WATERVIEW EAST PRELIMINARY PLAN

PCD File # SP-17-010

Project No./Code	181710214
Sheet Number	2 of 9

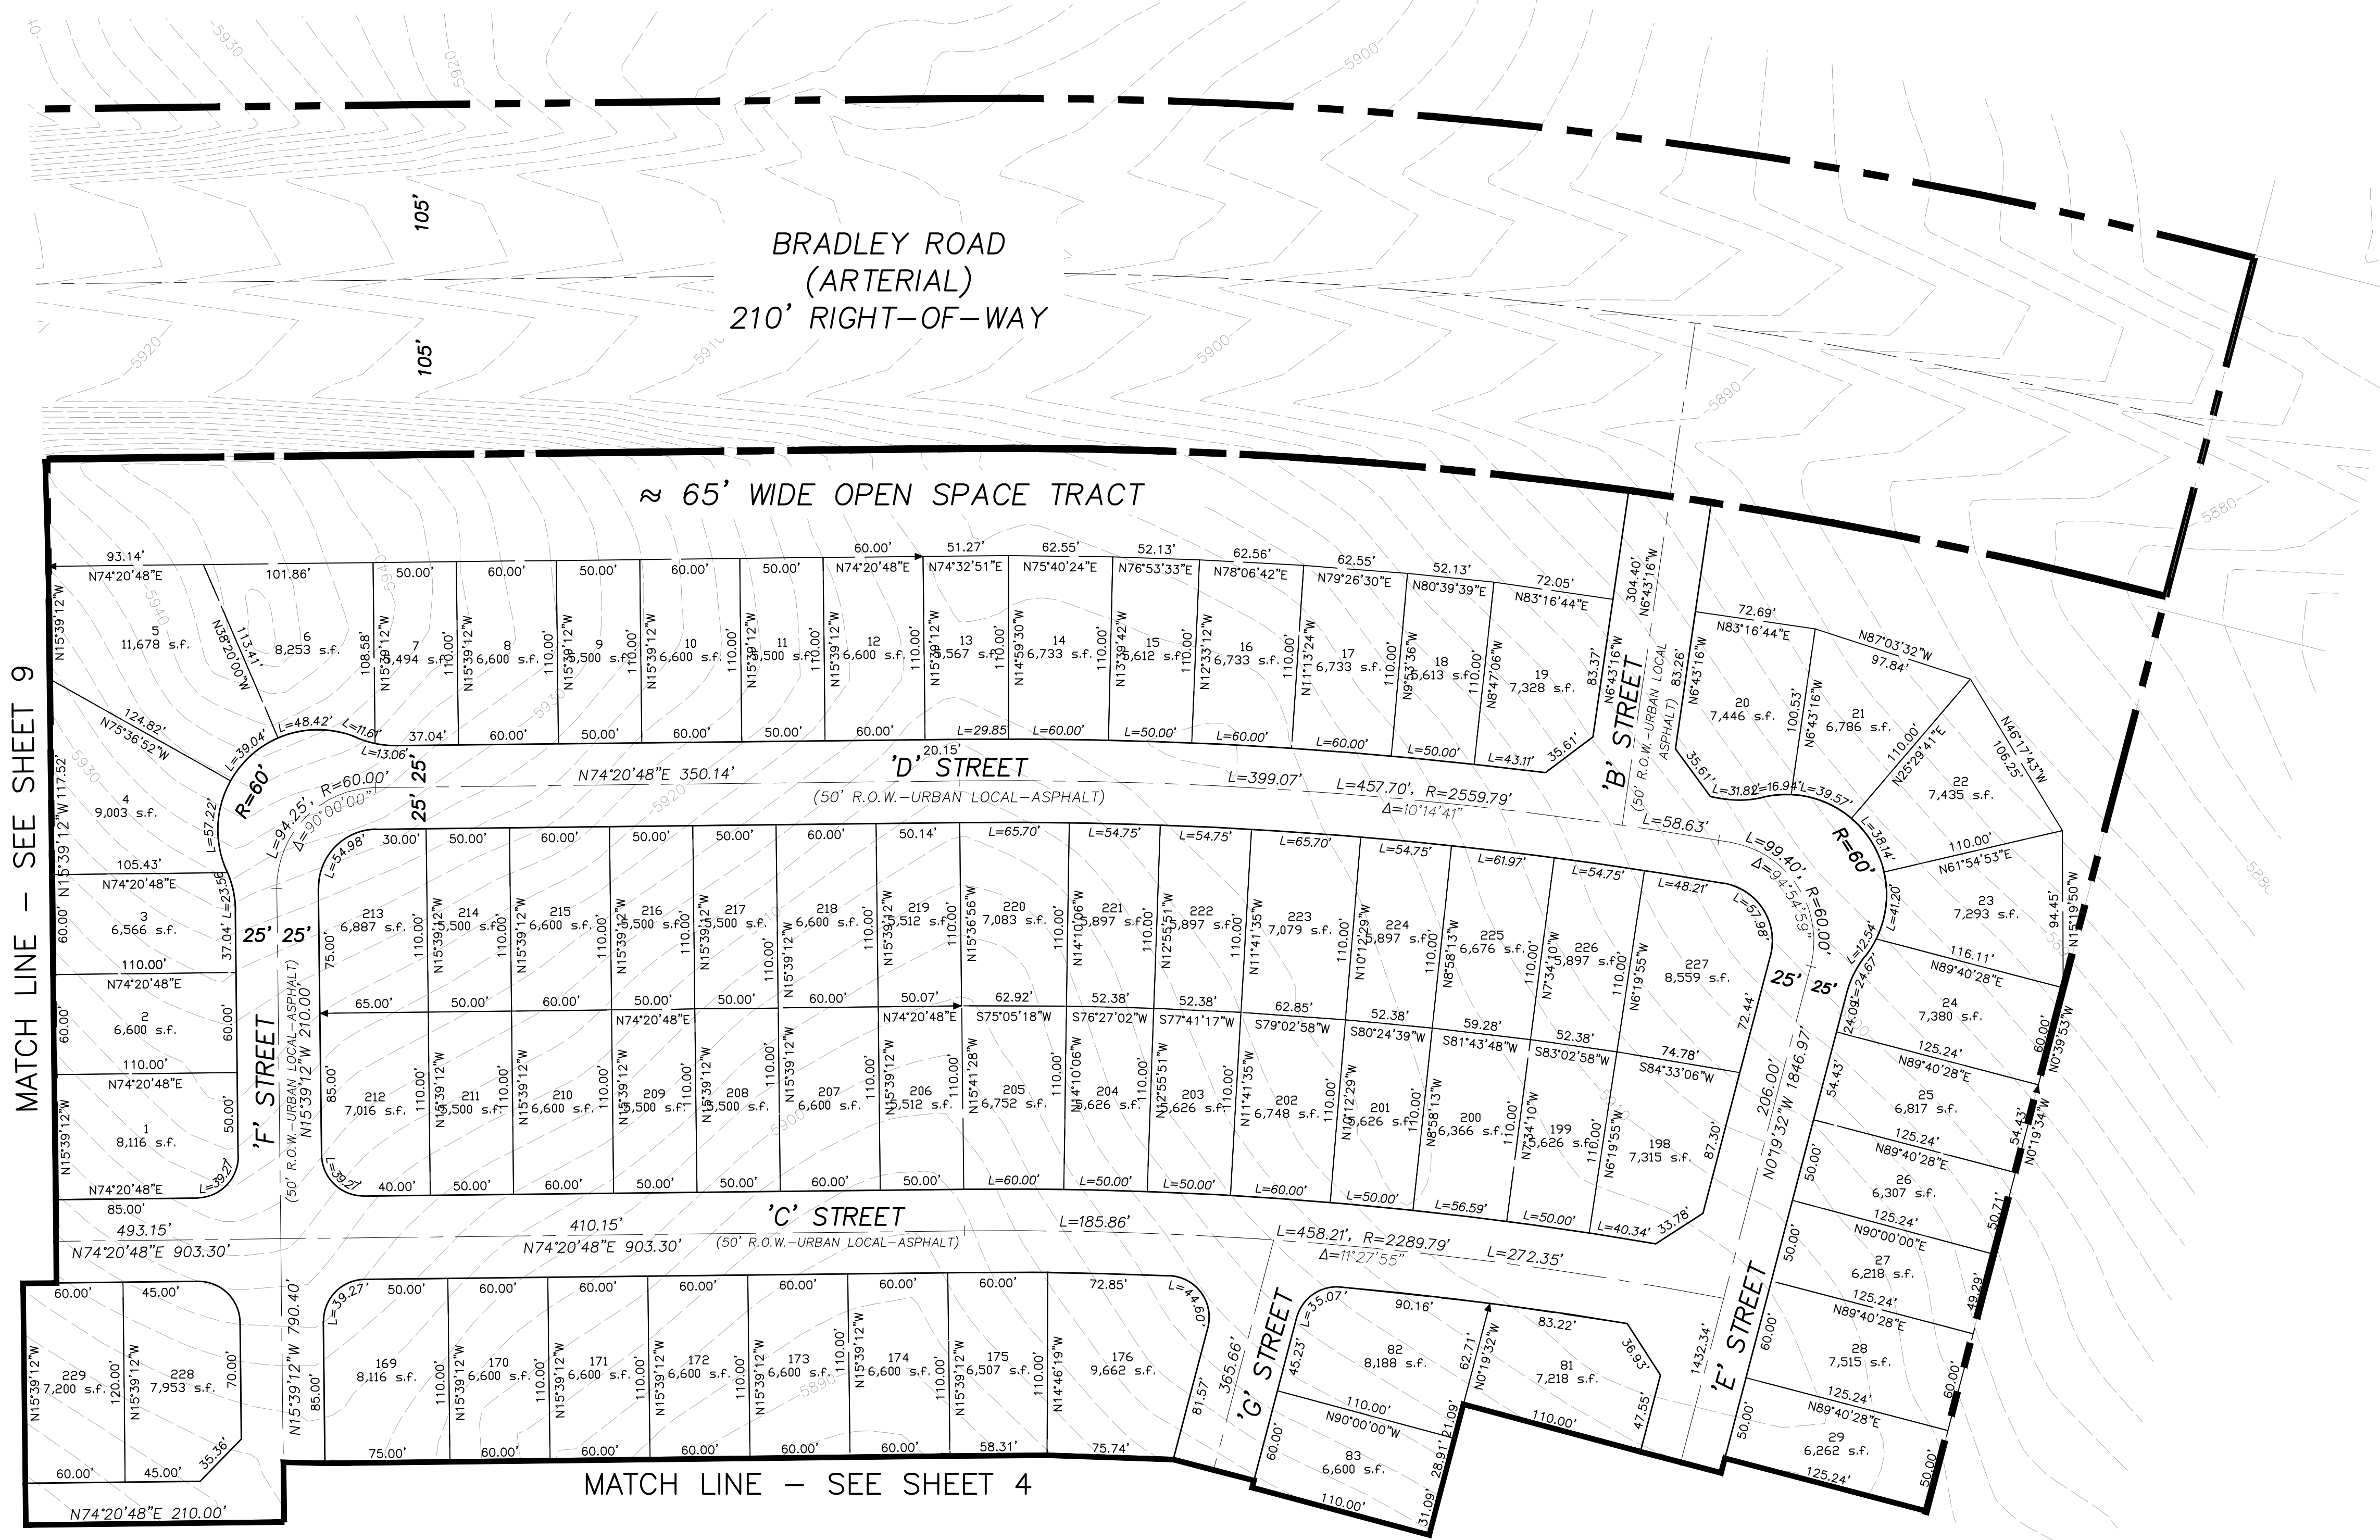
Show the roadway geometry (on and off site)
 Unresolved. Clarification, show proposed and existing surface improvements. i.e. C&G's, sidewalk, pedestrian ramps, trails if applicable.

Add a north arrow for the key map since this is not always the same orientation as the plan view.

Does not appear to meet intersection spacing criteria (175' centerline to centerline).
 Revise or update TIS to list all deviations that the applicant will be making and submit the deviation request form.

Sheet Number 4 of 9

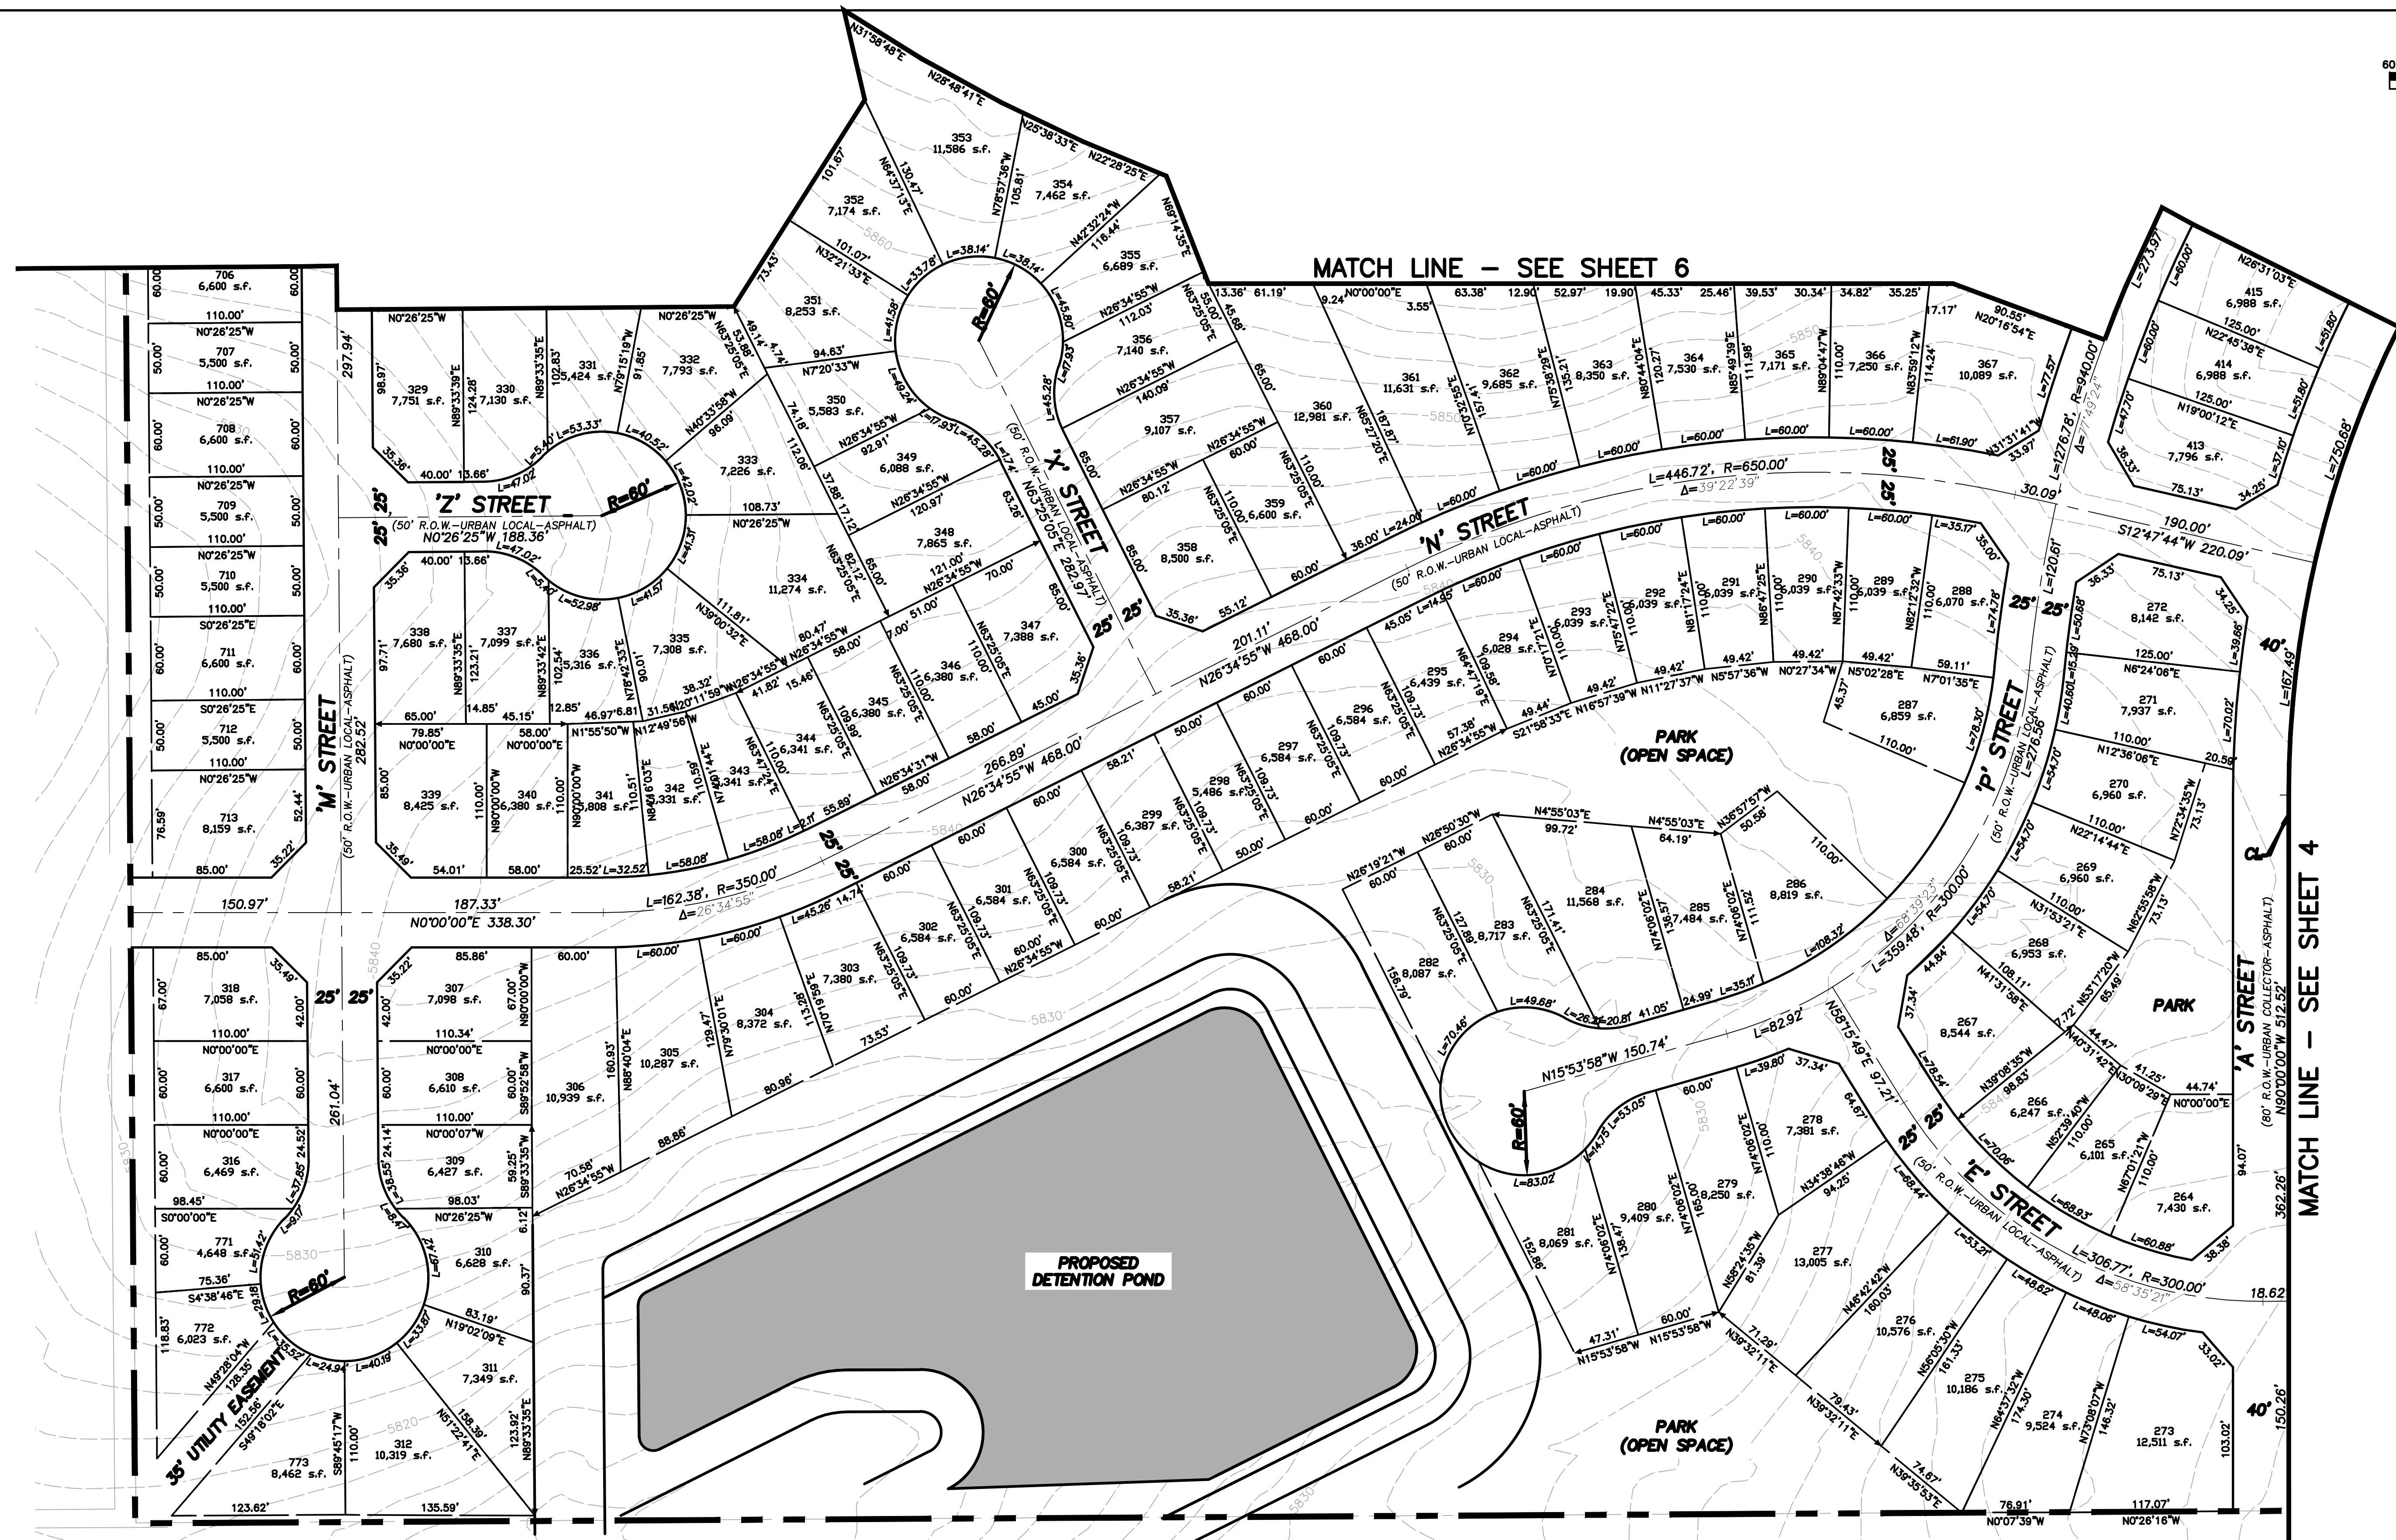
Please indicate this as the setback line.

Show the sight triangle on the intersections.
See ECM 2.3.6.G.

Locate all sight triangles that encroach into lots within a sight distance easement.

The easement shall be dedicated to the County. Maintenance of a sight distance easement shall be the responsibility of the property owner.
Unresolved.

Project No./Code	181710214
Sheet Number	6 of 9

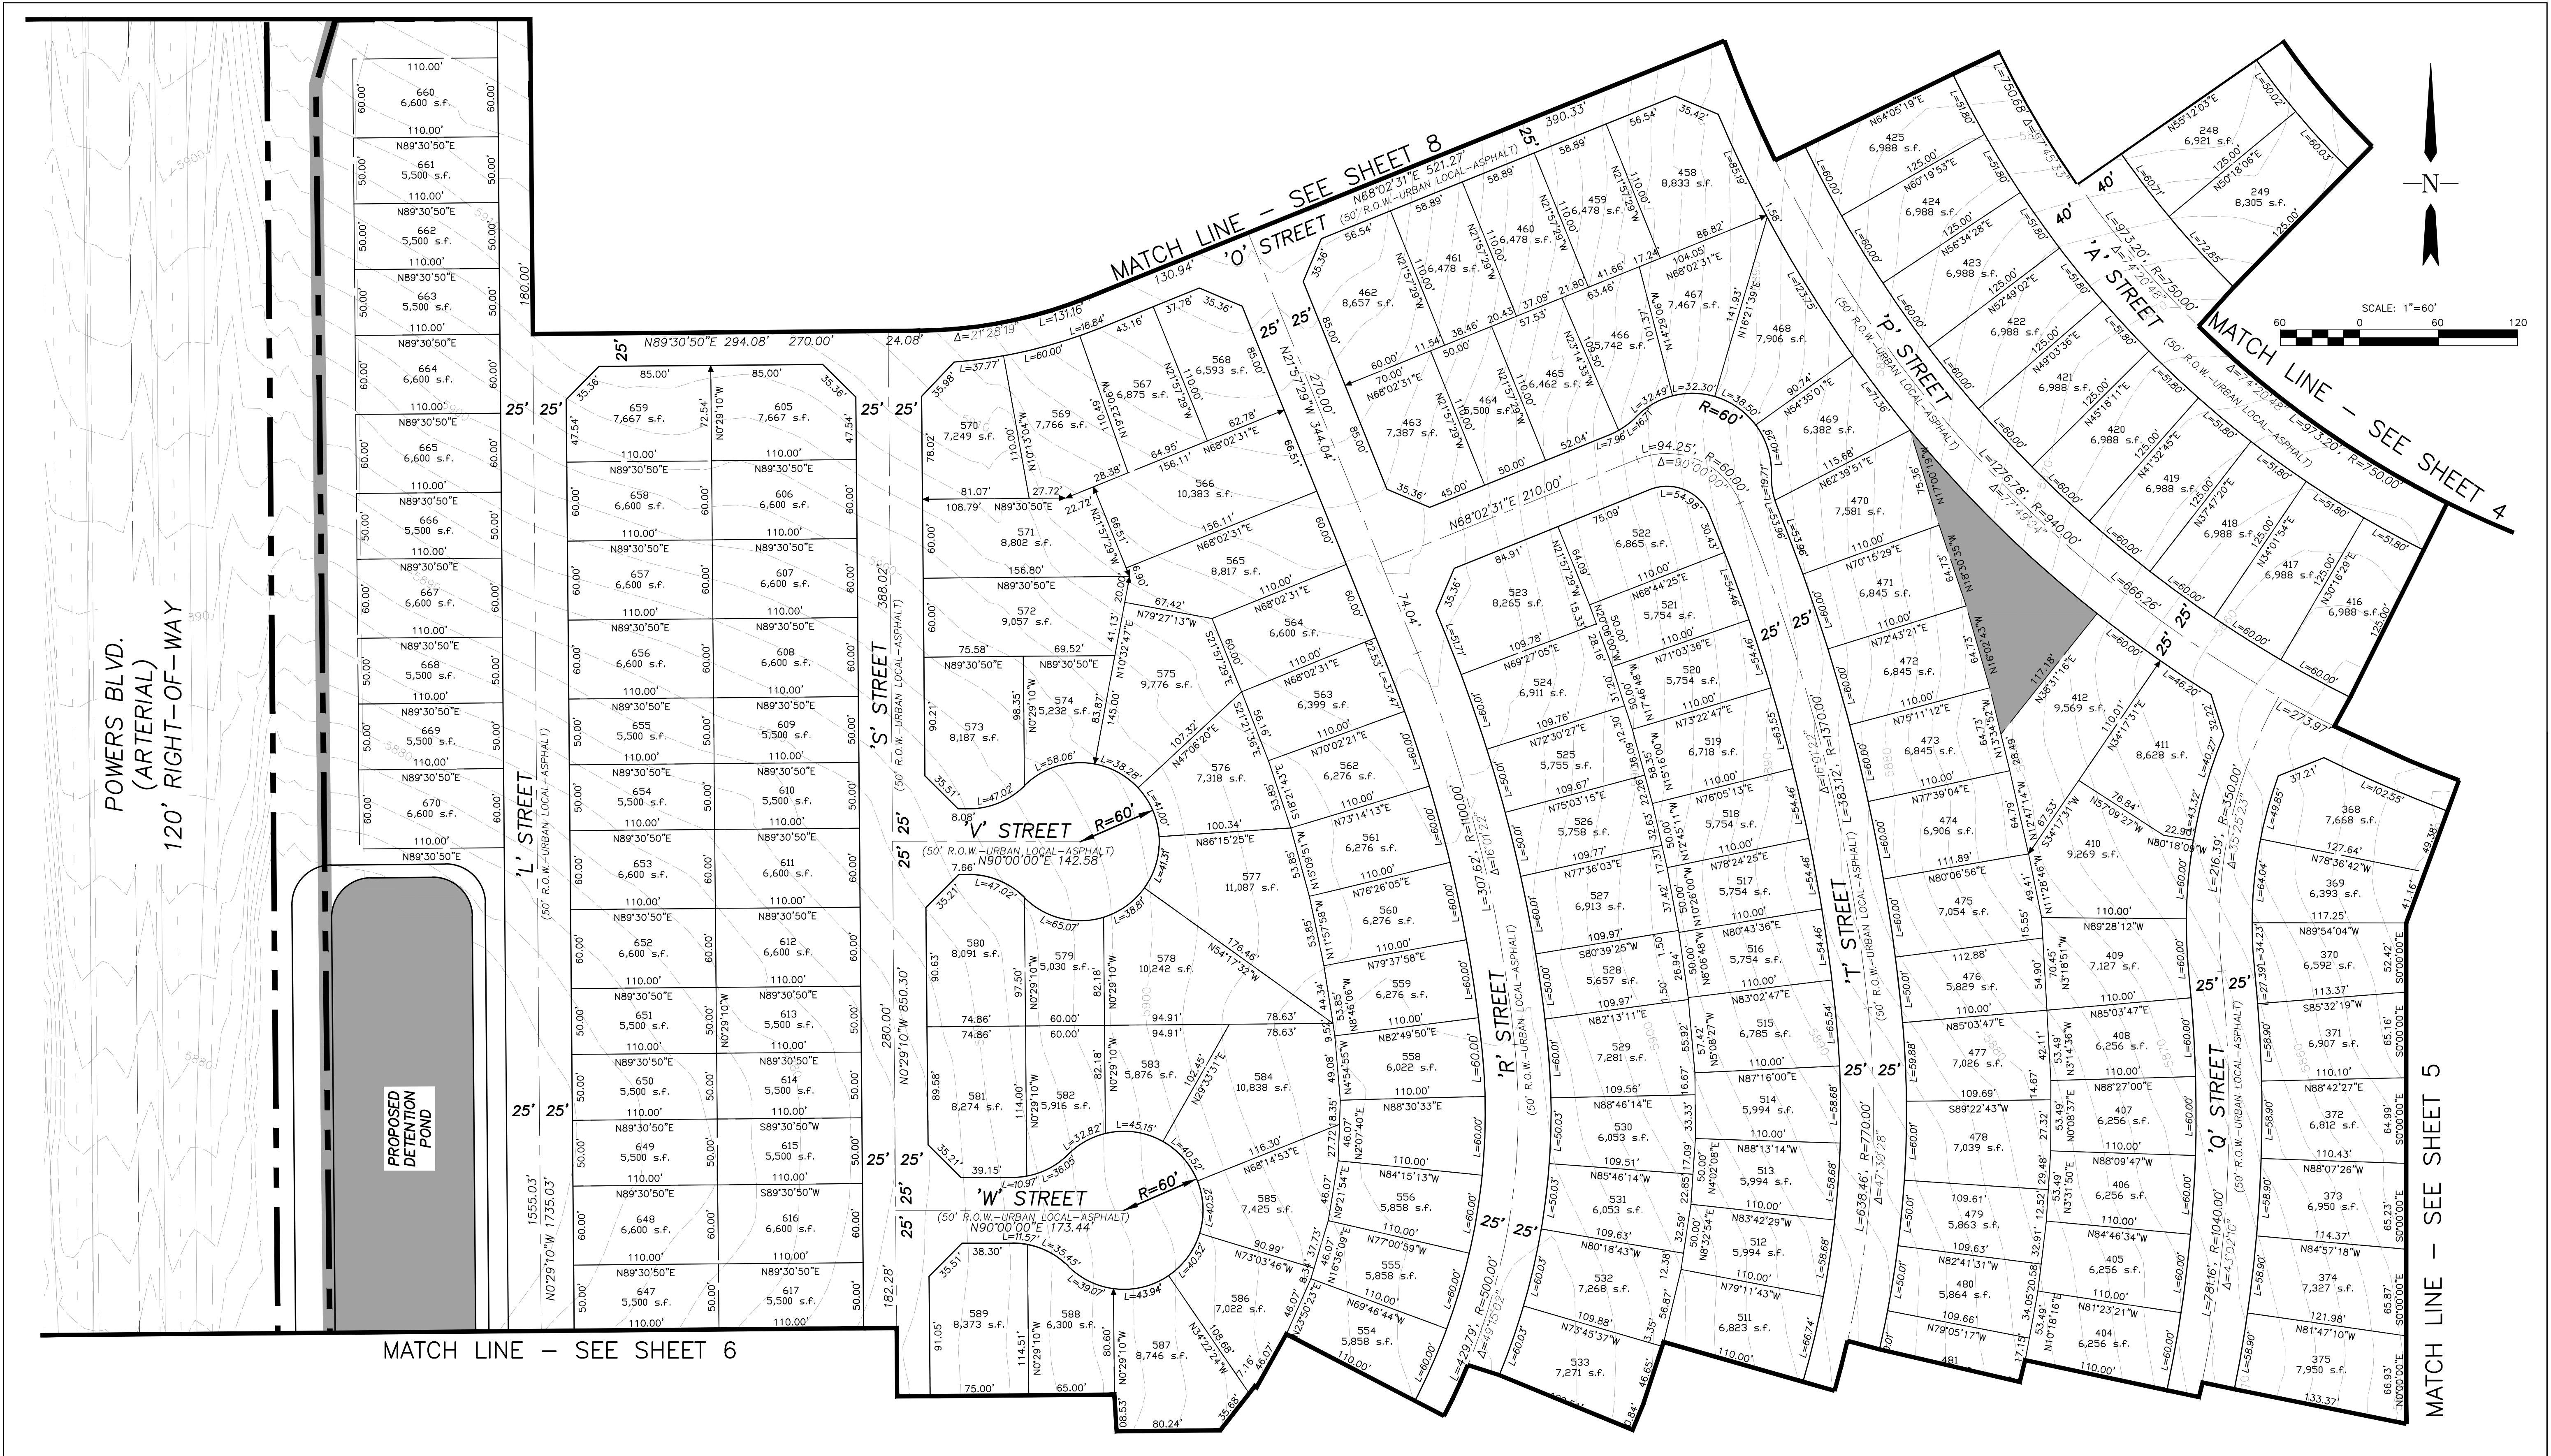
Use EPC nomenclature.
Revise to Urban
Non-Residential
Collector
